APPLICANT'S RESPONSE TO ISSUES RAISED AT DEADLINE 3

Drax Bioenergy with Carbon Capture and Storage

Document Reference Number: 8.10.3

PINS Reference: EN010120

PROJECT:	DRAX BECCS DCO				
TITLE:	FIGURE 1 LANDSCAPE AND BIODIVERSITY MITIGATION PLAN

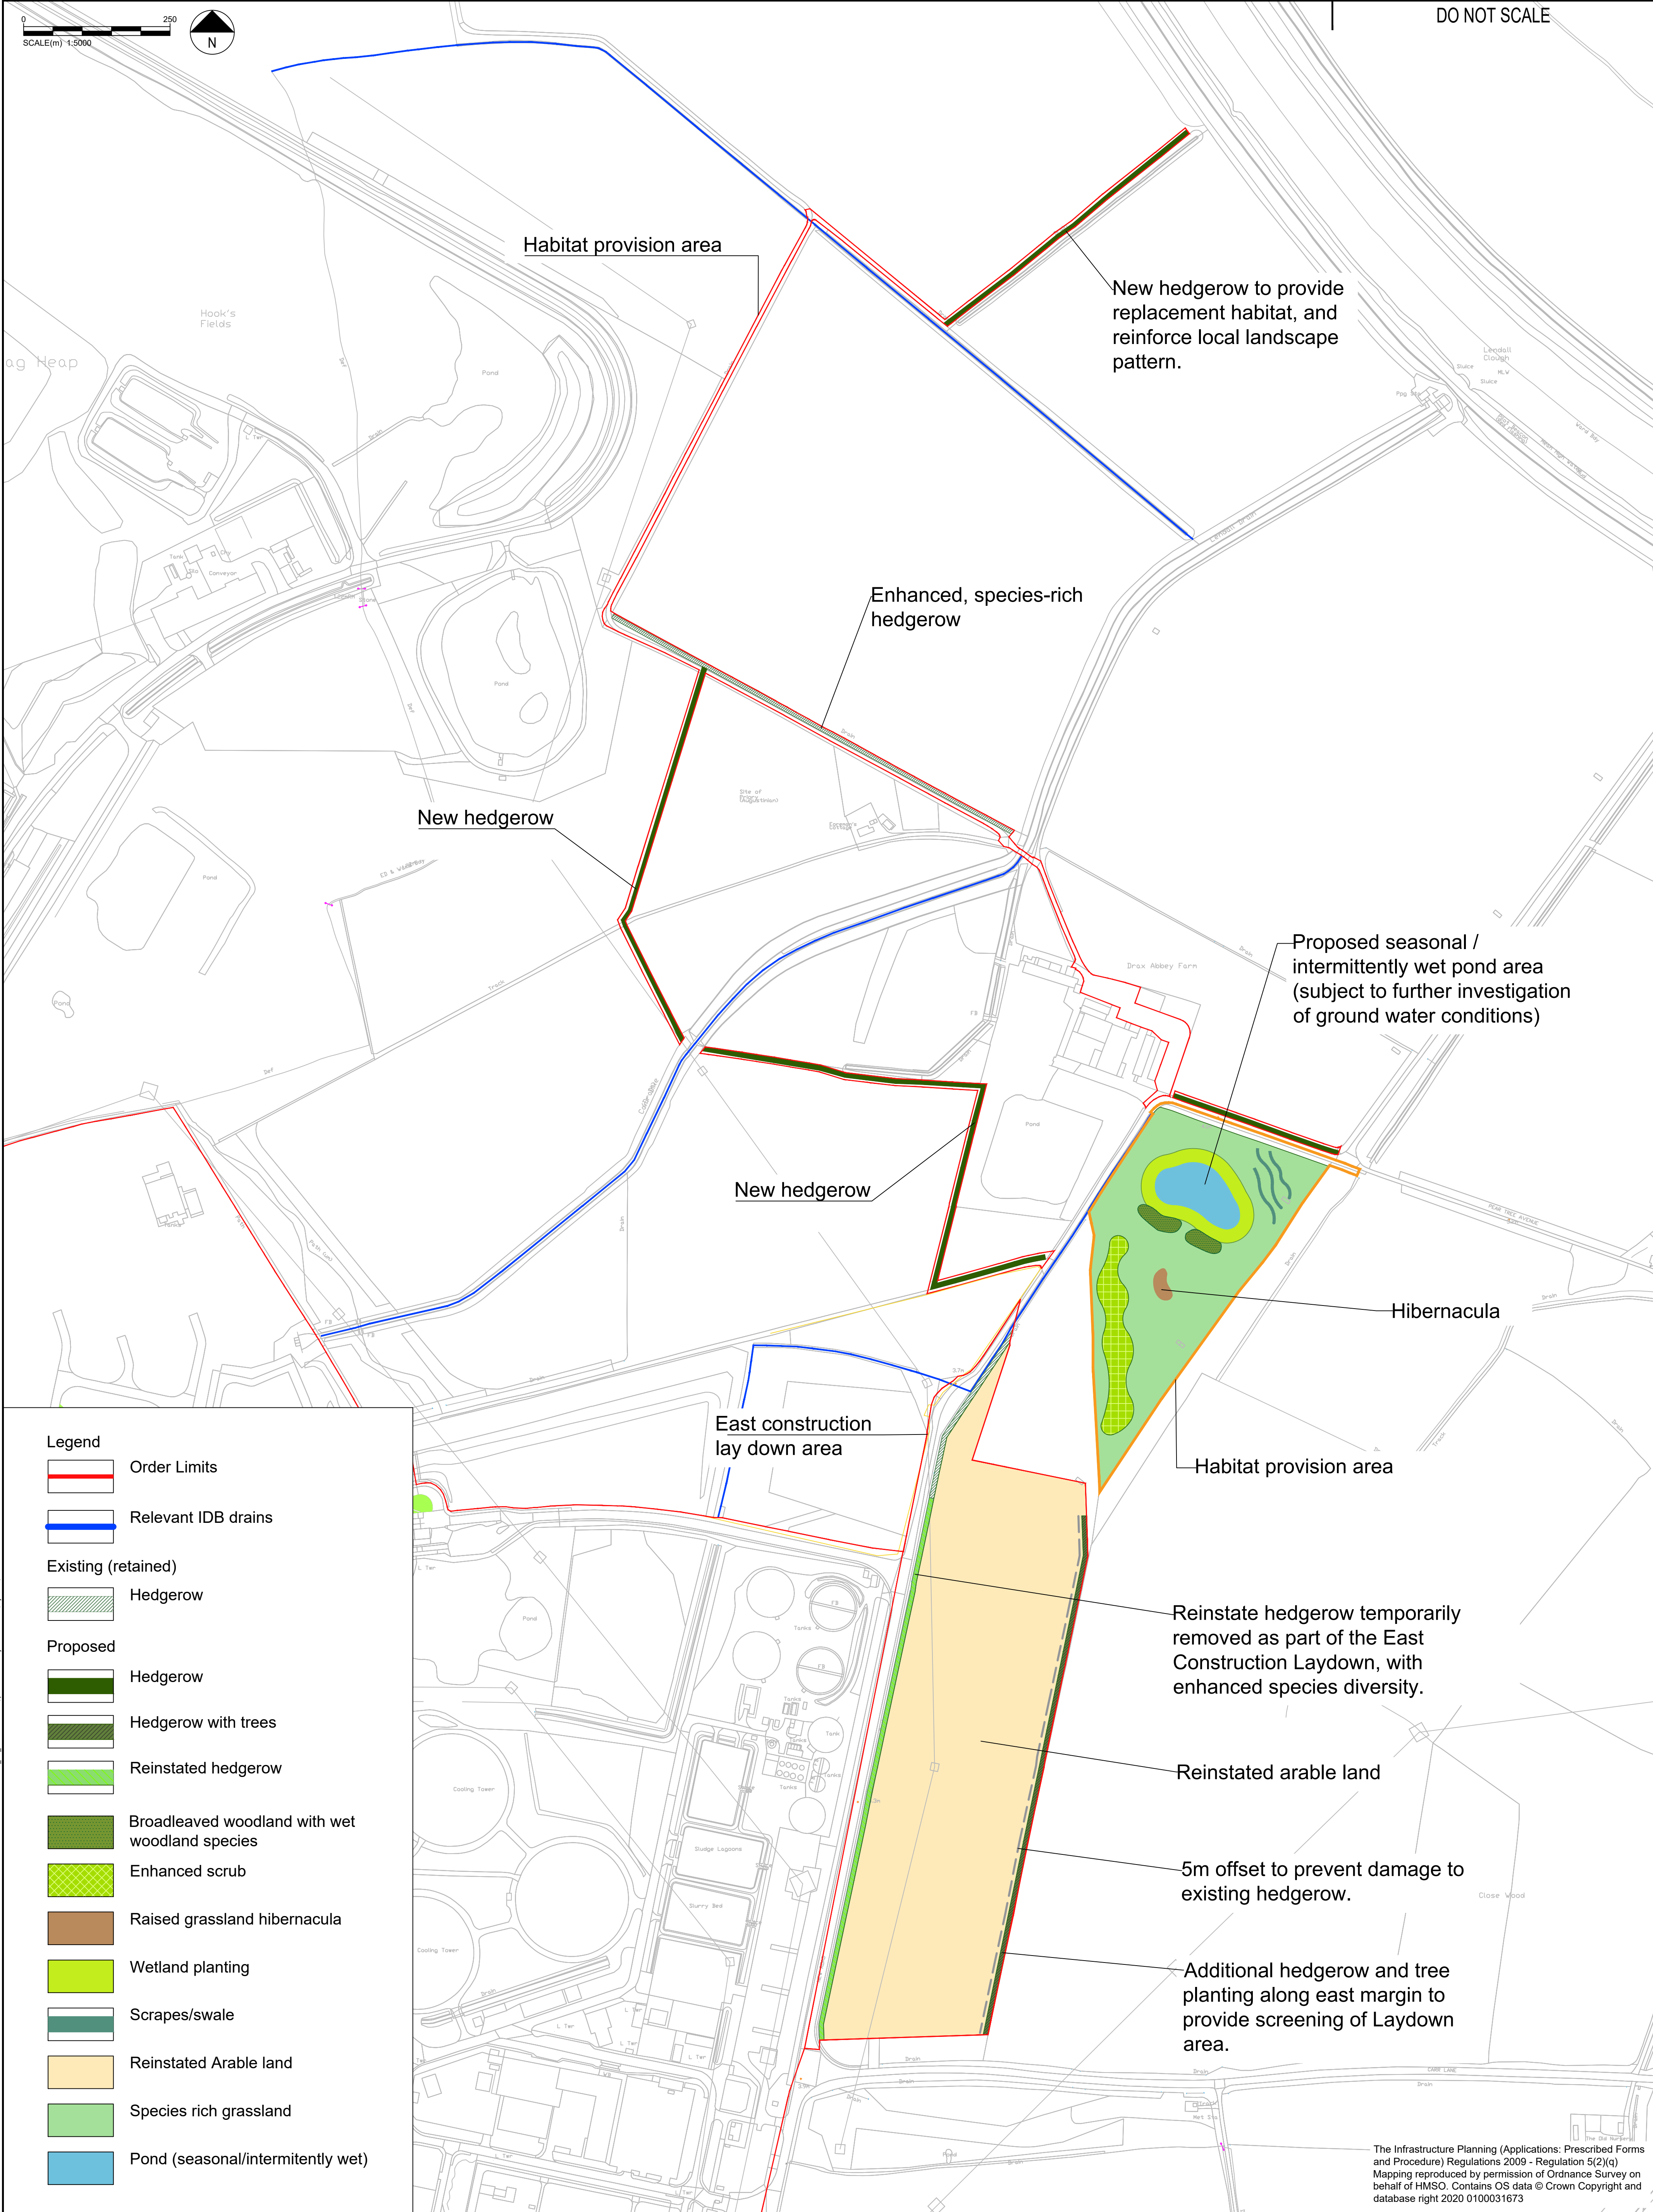
2.13 (S4, P1-P2)	<p><u>Proposals</u></p> <p>The Authorities would wish to see the following:</p> <p>1. The Plan titled Outline Landscape and Biodiversity Strategy Vol 2 Figure 3 Existing Retained Vegetation [APP-183] includes an area coloured light green indicated as '<i>area to accommodate carbon dioxide construction compound (detailed design will avoid the unnecessary removal of existing vegetation).</i>'</p>	<p>The area identified by the Authorities forms the perimeter planting to the northern end of Drax Power Station and is proposed for temporary use as a construction compound. As identified on Figure 3 Existing Retained Vegetation (APP-183) of the Outline Landscape and Biodiversity Strategy - Volume 2 the planting in question will not be removed where this is avoidable. This is secured through reference to work no. 2 within Requirement 7 of the DCO, which requires a written strategy for that part, which is substantially in accordance with the outline landscape and biodiversity strategy, has been submitted to and, after consultation with NYCC. In this</p>

Response Ref. (Location in Original Submission)	Comment	Applicant's Response
	This should be amended to either say that existing vegetation will not be removed (the Authorities preference) or that any vegetation that is required to be removed will be reinstated. If existing vegetation is to be removed and reinstated, it should be made clear why this is necessary and what alternative options have been considered and discounted which would not result in vegetation removal. This principle should be applied to any aspects where existing vegetation is threatened.	<p>way, any requirement to impact this area of planting will be discussed and agreed with NYCC prior to works commencing.</p> <p>This is agreed to with respect to this Proposed Scheme however, as part of the Humber Low Carbon Pipelines application the location of the National Grid AGI has not yet been confirmed and may subsequently impact this planting and will be the subject of a further planning application. The Applicant is therefore unable to confirm the permanent safeguarding of the planting in question.</p> <p>This relates to the light green area shown on OLBS Figure 3 (Existing Retained Vegetation) (APP-183) which could be affected by Humber Low Carbon Pipeline, and therefore, until the location and component infrastructure of the carbon dioxide receiving compound is confirmed, the area needs to remain as 'light green' because the Applicant does not yet know where the infrastructure will be placed. However, this will be refined as the detailed design for both schemes progress and, furthermore, the final design will be included in the LBS.</p> <p>The approach generally to how any removal and replanting of vegetation would be justified and approved via the process set out in Requirement 7 was explained by the Applicant at ISH3 and recorded in the Applicant's written summary of oral submissions from ISH3, submitted at Deadline 4 – Agenda Item 4.</p>
